**RE: SHOALHAVEN STARCHES EXPANSION PROJECT (MP06\_0228 MOD 15)  
MODIFICATION APPLICATION 15 – PROPOSED CO2 PLANT  
RESPONSE TO SUBMISSIONS**

I refer to your email dated 1<sup>st</sup> May 2018 in which you seek responses to submissions made by government agencies and the public in relation to the above Modification Application (Mod 15). Our firm has been engaged by Shoalhaven Starches and Supagas to prepare this submission in response to issues raised by the government agency and public submissions made in relation to the above Modification Application.

TITLE : NEW PROPOSED OVERALL LAYOUT TANKER ACCESS PLAN VIEW		
DWG. No.	REV.	
GLPP16027-L1-005	A

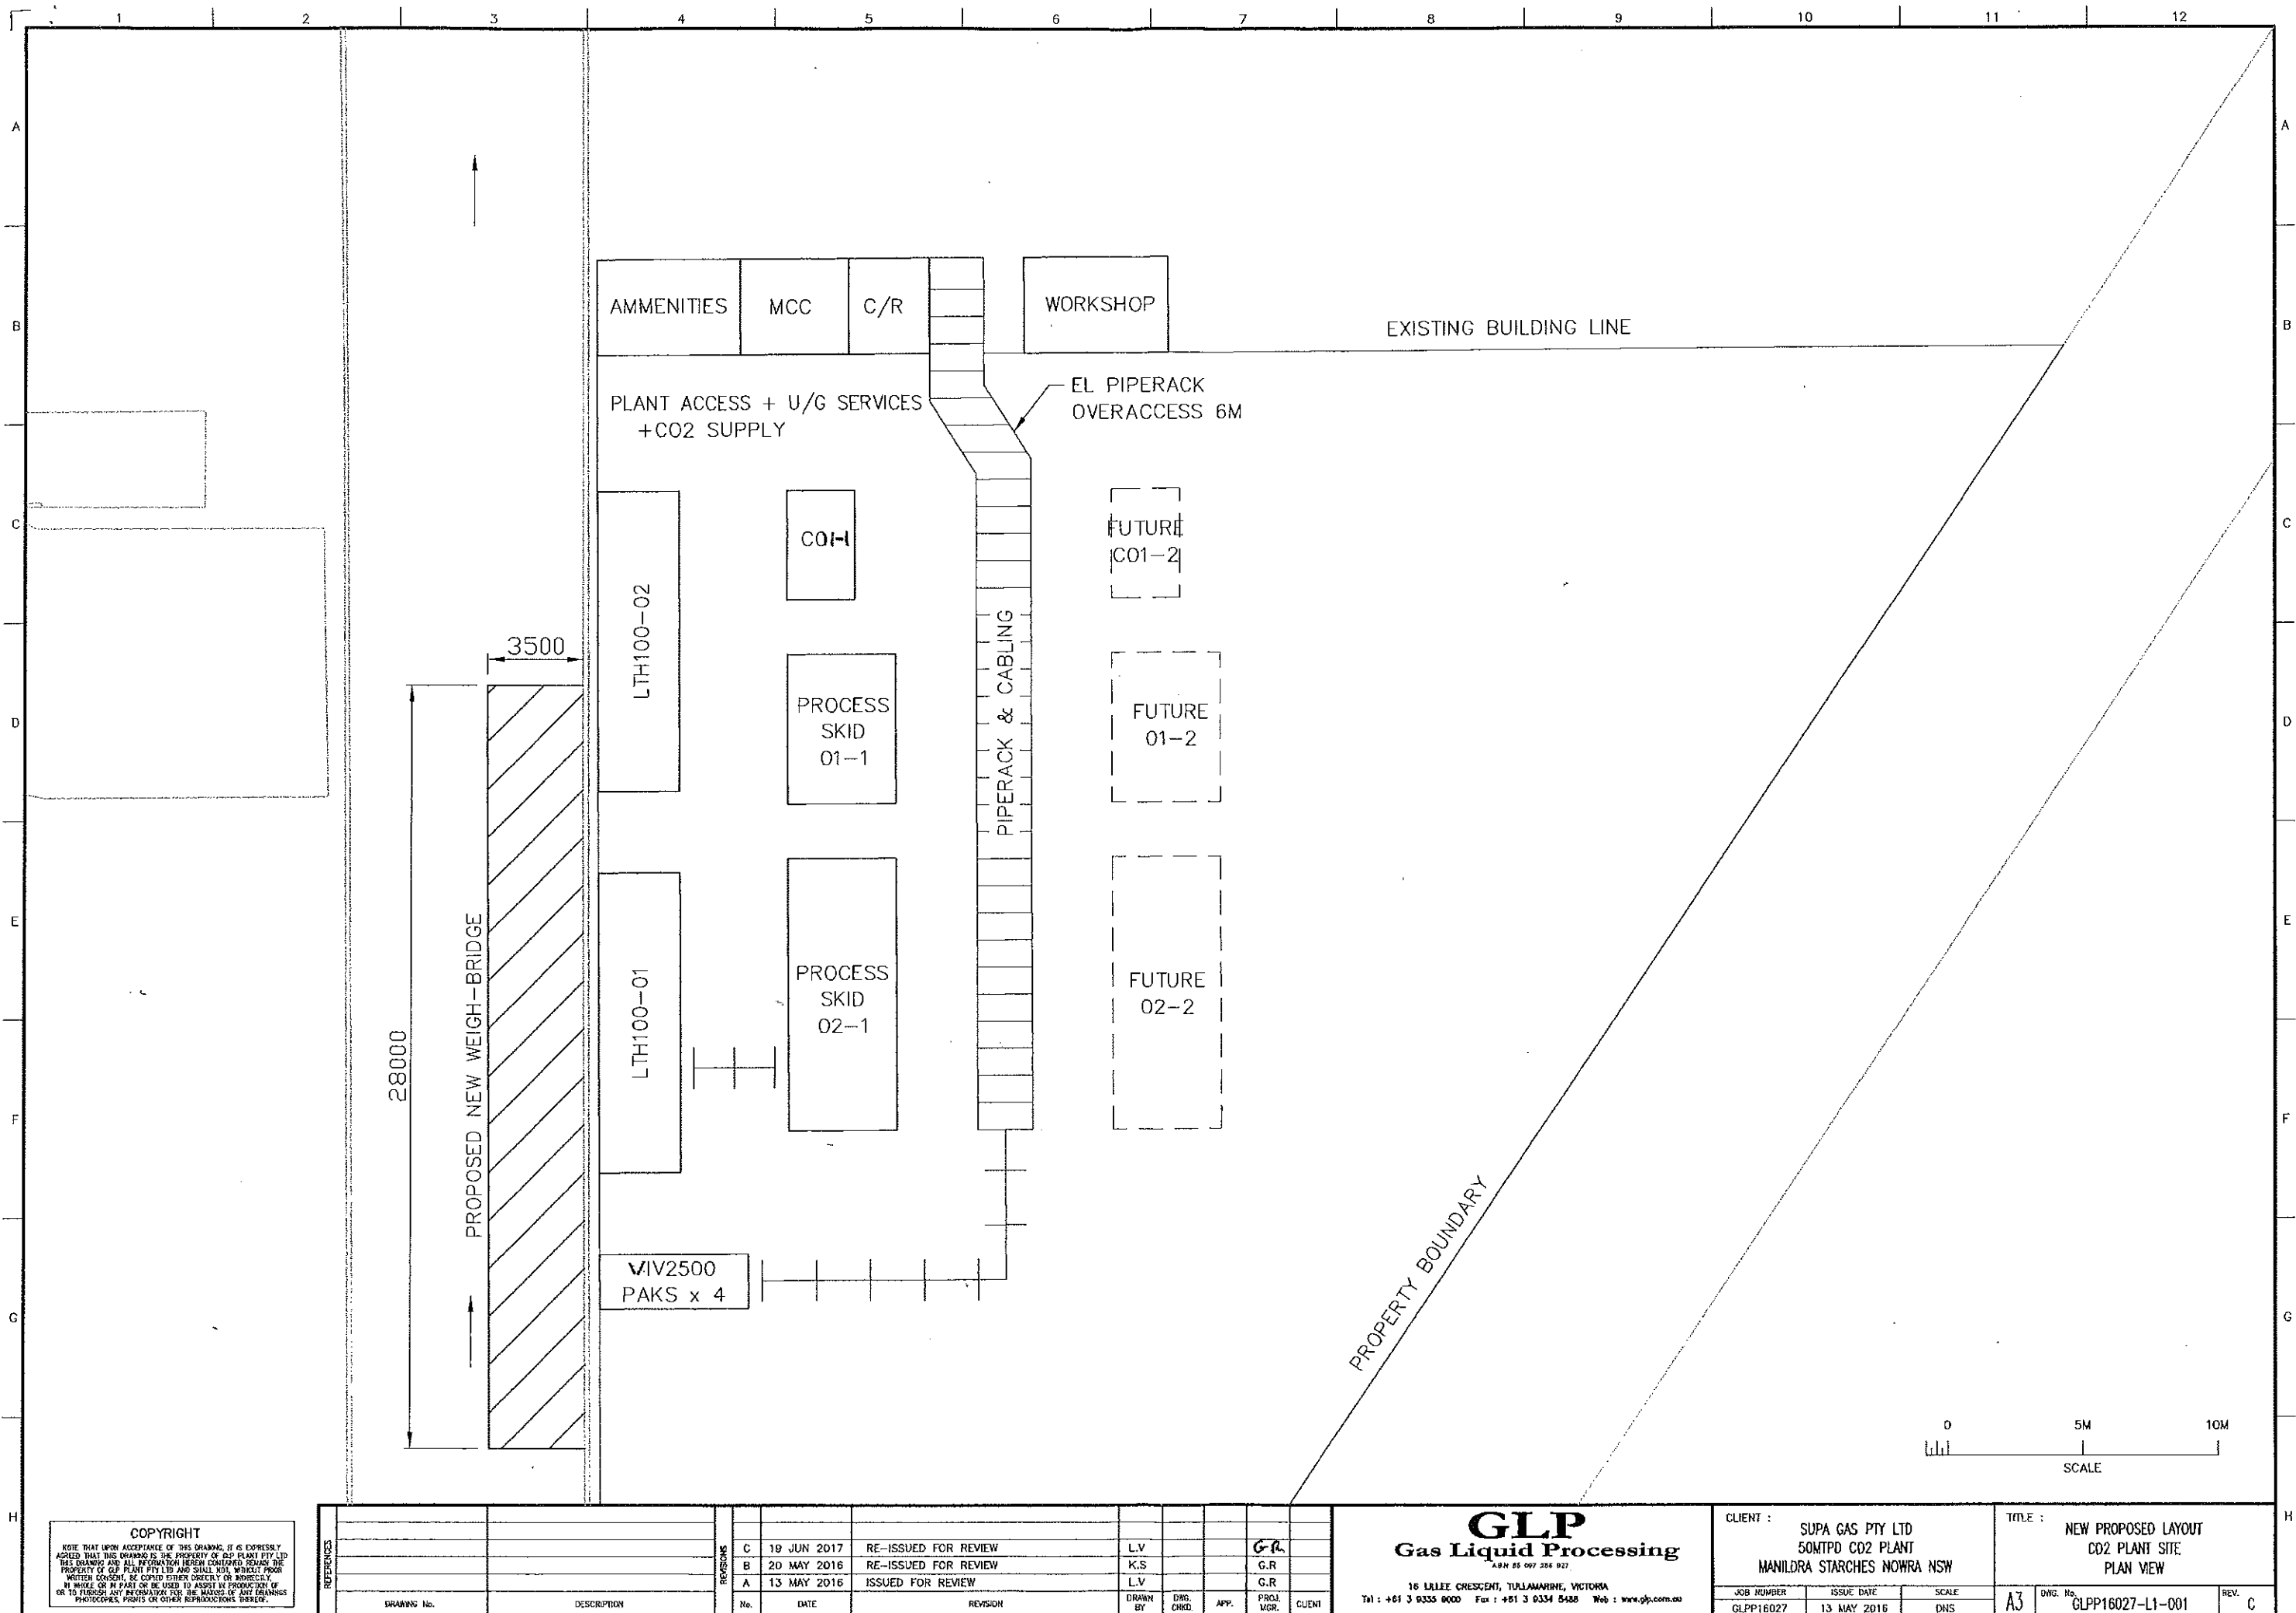
- 1. The Traffic Impact Assessment and plans indicate and show that B-Double trucks are going to access the site through the building. The submitted turning path plan shows the B-double truck also hitting the building between the roller door access points. Refer to the images below, which also show that the southern side of the building is for exit only.*

- 2. Clarification is required as to whether the development needs the B-Double trucks to enter the building other than for manoeuvring reasons.*
- 3. During Council's inspection of the site numerous semi-trailer tanker trucks were parked at the rear southern side where the B-Doubles are proposed to access the site. The submitted turning path plan also shows these tankers. The proposed location for parking of these tankers needs to be confirmed.*

- 4. The existing approved tear drop access/exit point onto Bolong Road is not a mountable island so access around the building from Bolong Road to the western side could be a difficult manoeuvre to achieve, as shown in the image above.*

- Attached to this submission is a revised truck turning swept path for a B-Double truck prepared by Allen Price & Scarrats demonstrating the swept path is able to be accommodated through the building without hitting the wall between the roller shutters.

- As detailed in Section 2.2.3 of the Traffic Impact Assessment prepared by ARC Consulting and which forms Annexure 7 to the EA in support of this Modification Application truck movements to and from the site will be generally consistent with the same truck access paths as that currently generated by the existing Meat Plant vehicles. There is no other reason for the trucks to enter the building as shown other than for manoeuvring purposes.

- The parking of semi-trailers tanker trucks to the rear of the site can be undertaken without interfering with the swept paths included in the application. In this regard this truck parking area can be relocated slightly to the north, with appropriate line marking, to enable the swept path shown to be undertaken without conflicting with this truck parking.

- The proposal does not rely upon access around to the west of the building from Bolong Road, as vehicles will enter the building and then pass through the building to the rear of the site as heavy vehicle movements already do for the site. As truck movements are able to utilise the access through the building there is no need for a heavy vehicle to manoeuvre around the western side of the building.
